OBJECTION CM/64/19/PL Langford Horsemere Green Lane

Plot 8 deliberate misrepresentation by applicant to ADC

Drawing Title:
HOUSE TYPE-F1
FLOOR PLANS

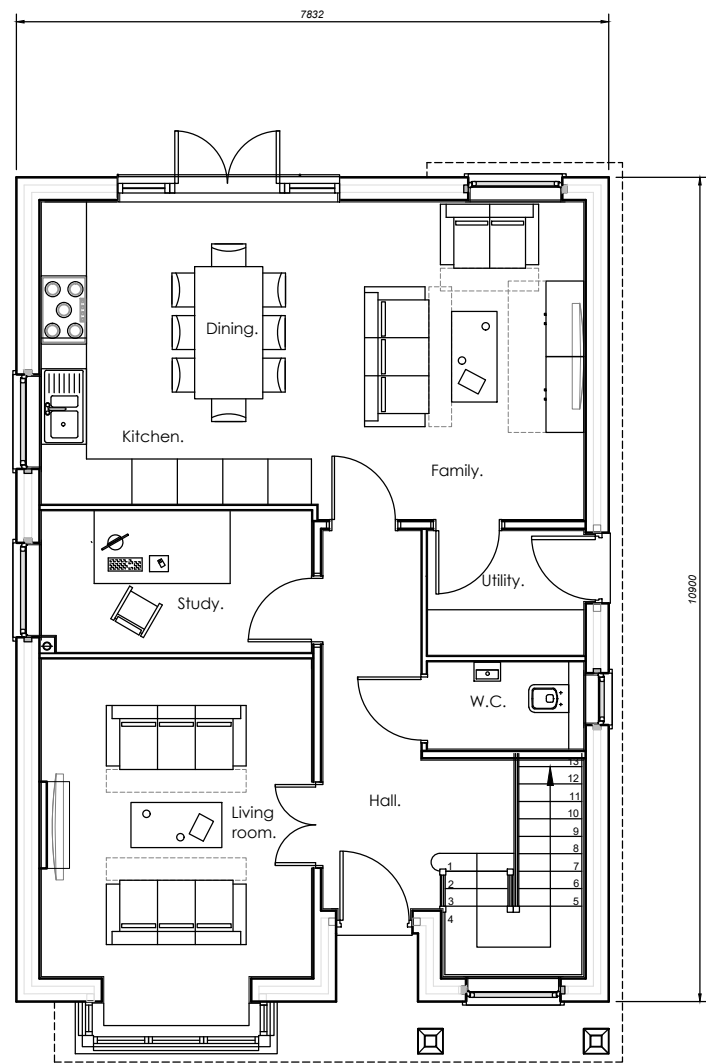
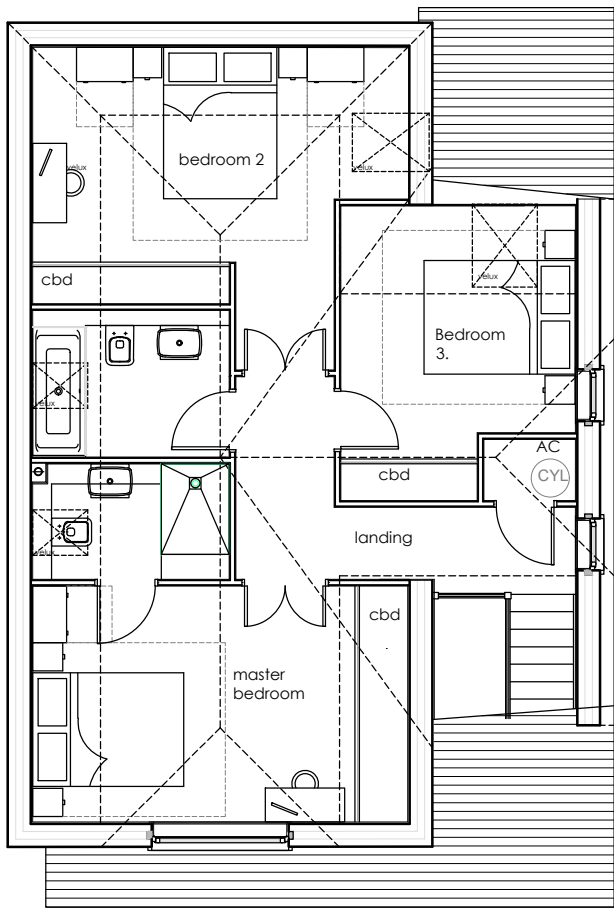
3. The value of my property has been badly affected.
4. PLOT 8 runs the length of my boundary. An application for a 4-bed house type E has been superseded by House type F described as a **3-bed BUNGALOW**. Having looked at the plans this is a **HOUSE** with 2 bedrooms and 2 bathrooms on the first floor, and one bedroom on ground floor. The whole length of the proposed house runs the whole length of my boundary, with permanent structure within feet of my fence. This is very intrusive, and will obliterate light for the majority of the day, completely unacceptable. I speak on behalf of myself and my affected neighbours.
